**Re: Moorebank Precinct West Stage 3 (SSD-10431) – Liverpool City Council
Objection**

Liverpool City Council was invited to comment on the Moorebank Intermodal West Stage 3 (MPW Stage 3) State Significant Development Application (SSD-10431). It is noted that Council previously submitted advice regarding the request for Secretary's Environmental Assessment Requirements (SEARs). That advice is attached for your information and forms part of this submission.

Re: Moorebank Precinct West Stage 3 – Liverpool City Council Advice on SEAR's

# STAGED PLAN OF PROPOSED SUBDIVISION OF LOT 1 DP1197707 AND LOT 100 DP1049508

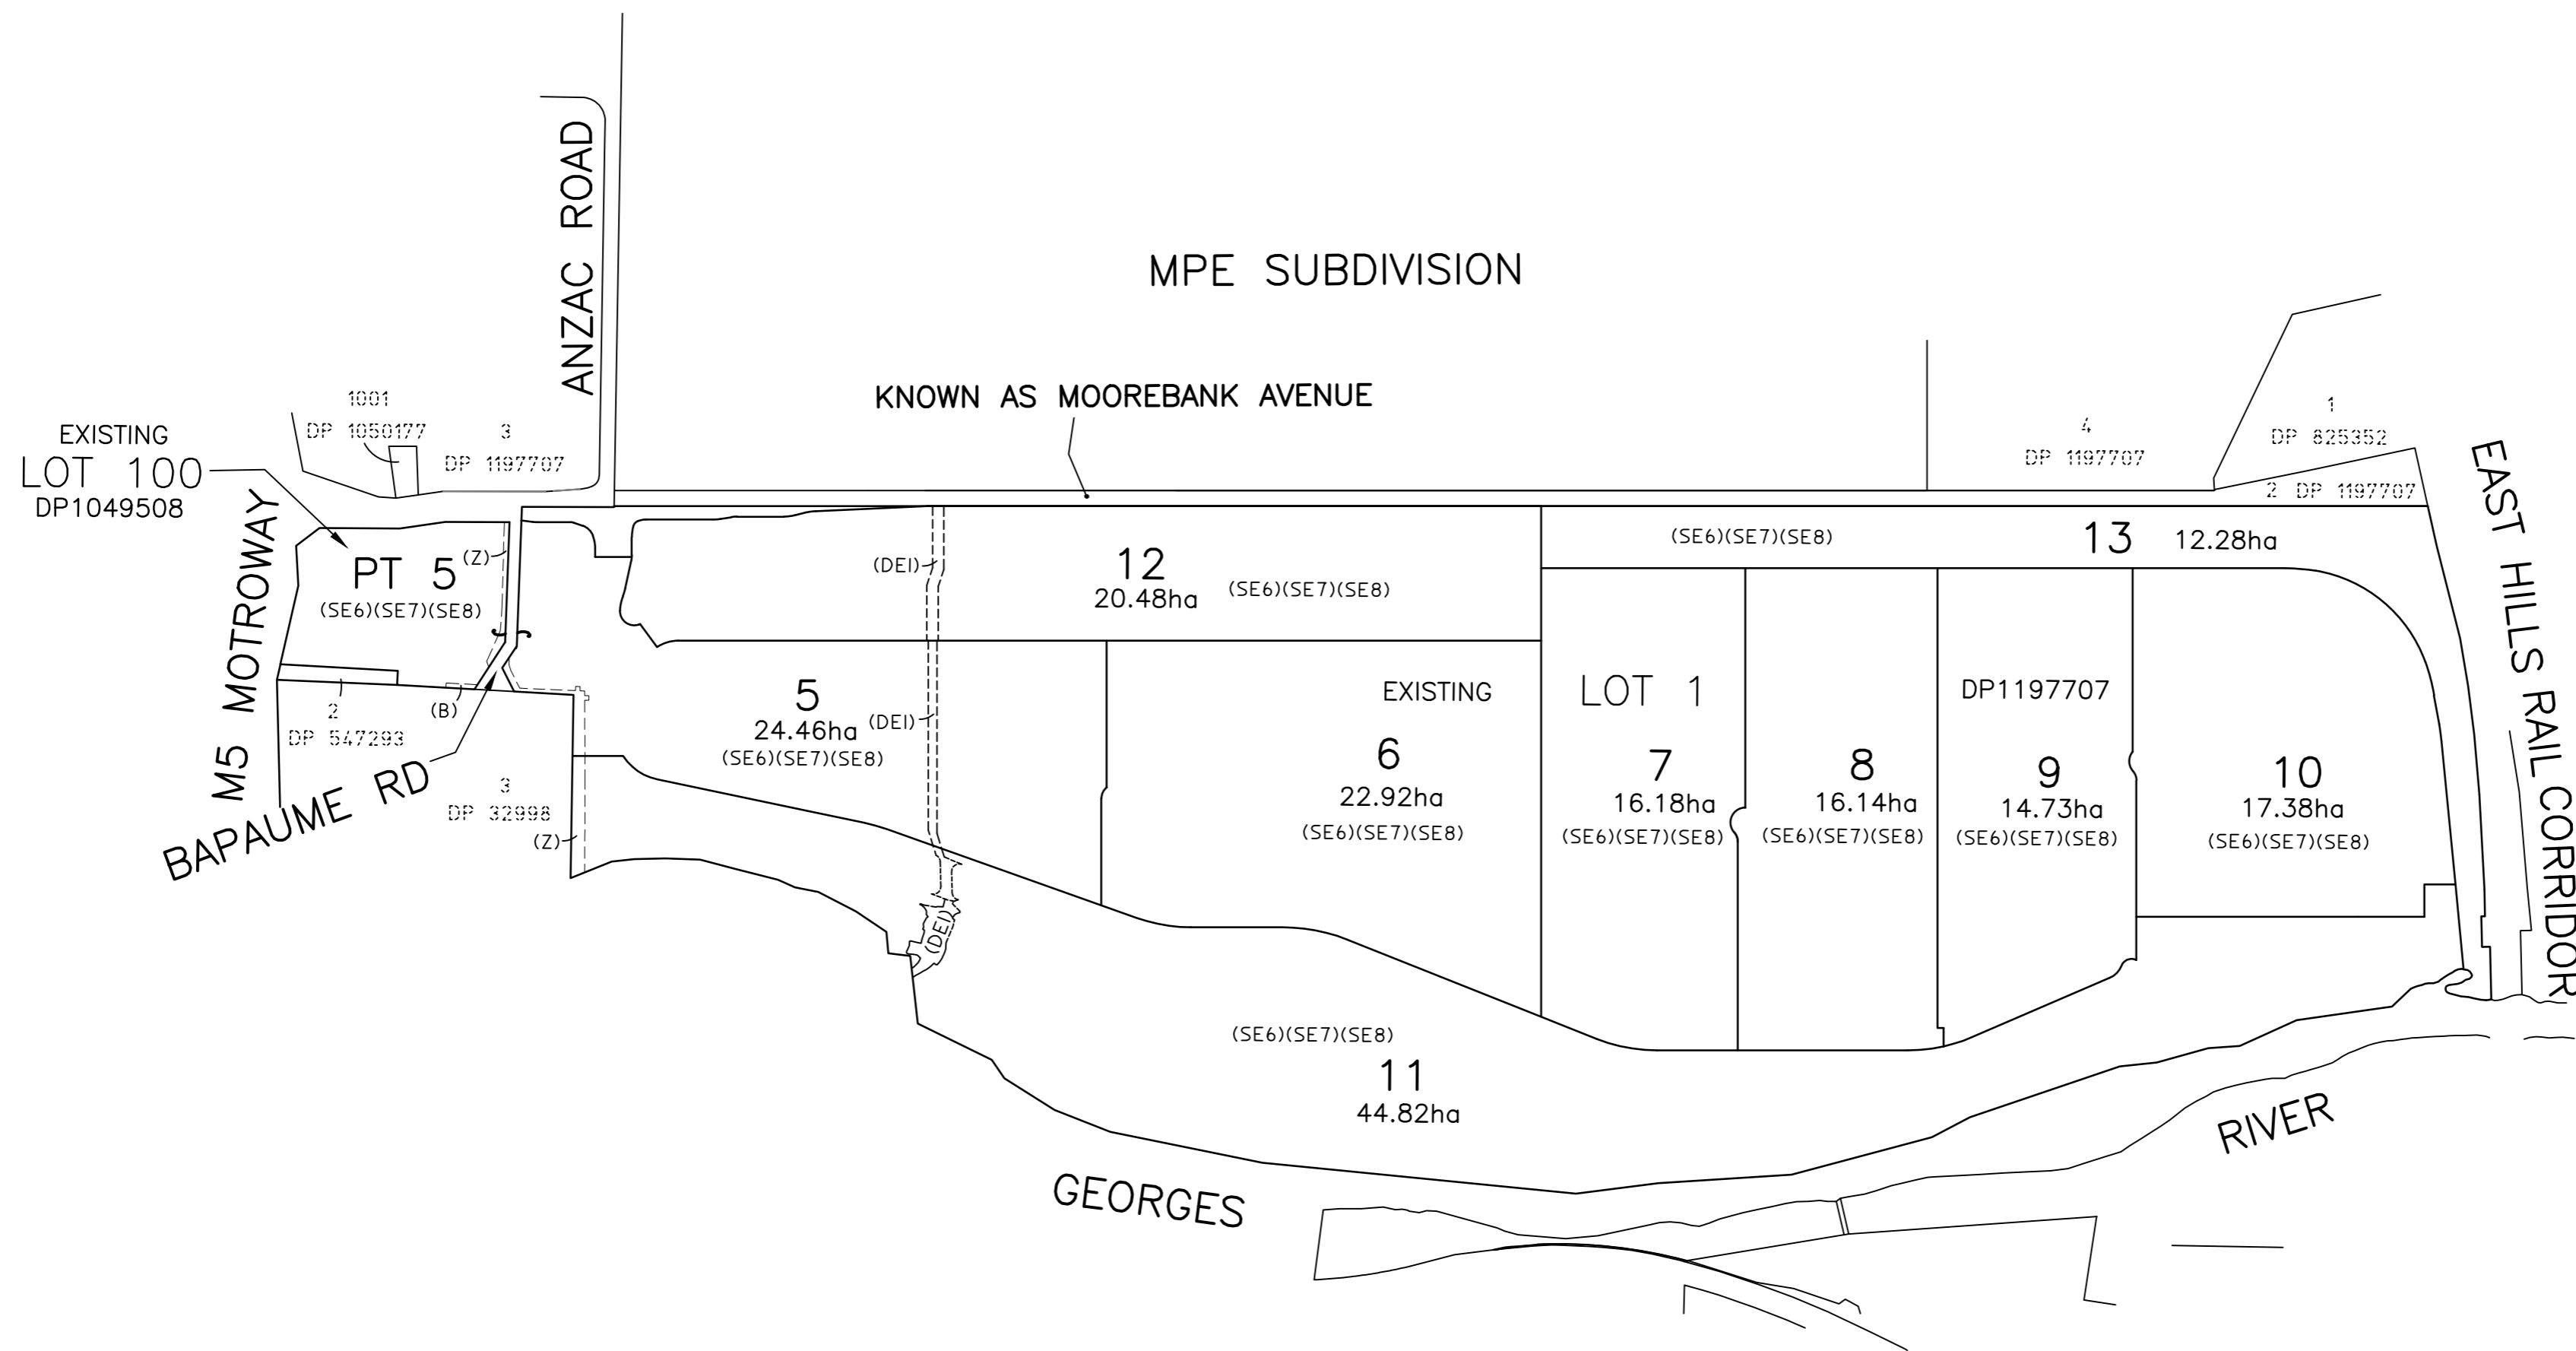
The MPW Stage 3 proposal includes the progressive subdivision of the site into nine (9) allotments. This proposed subdivision will result in a significant non-compliance with Clause 4.1 of the Liverpool Local Environmental Plan 2008 (LEP) in the order of 11,987.72%, or a 107.72ha shortfall in the minimum required lot size. It is noted that Council provided a detailed response on the applicant's request for SEARs detailing concerns regarding this contravention of the development standard.

- Objective 1(c) in Clause 4.1 Minimum subdivision lot size seeks to prevent fragmentation of land which would prevent the achievement of the extent of development and nature of uses envisaged for particular locations. The existing

120ha minimum lot size control was established when the site was rezoned for an intermodal development in order that a holistic approach is undertaken for the construction, operation and management of an intermodal across the entire precinct. The rezoning of the site was not intended to facilitate development of an industrial estate, rather an intermodal development

- The application states that the lot layout design will be “characteristic of similar nearby industrial areas. As stated above, the intermodal development is not an industrial park or estate but instead a holistic intermodal freight terminal.
- The applicant’s response/justification to Clause 4.6(1b) states the following:

- The applicant’s response/justification to Clause 4.6(3a) states that “*exception to the existing development standard would facilitate subdivision of the MPW site as envisaged and approved*”. This directly contravenes Condition E26(a) of the Concept Approval SSD 5066 MOD 1.
- The applicant’s response/justification to Clause 4.6(5b) states that “*there is no public benefit to maintaining the development standard, thereby prohibiting subdivision of the MPW site, in this case.*” Council reiterates its concern that the proposed contravention of the minimum lot size will compromise the coordinated and holistic operation and management of MPW.
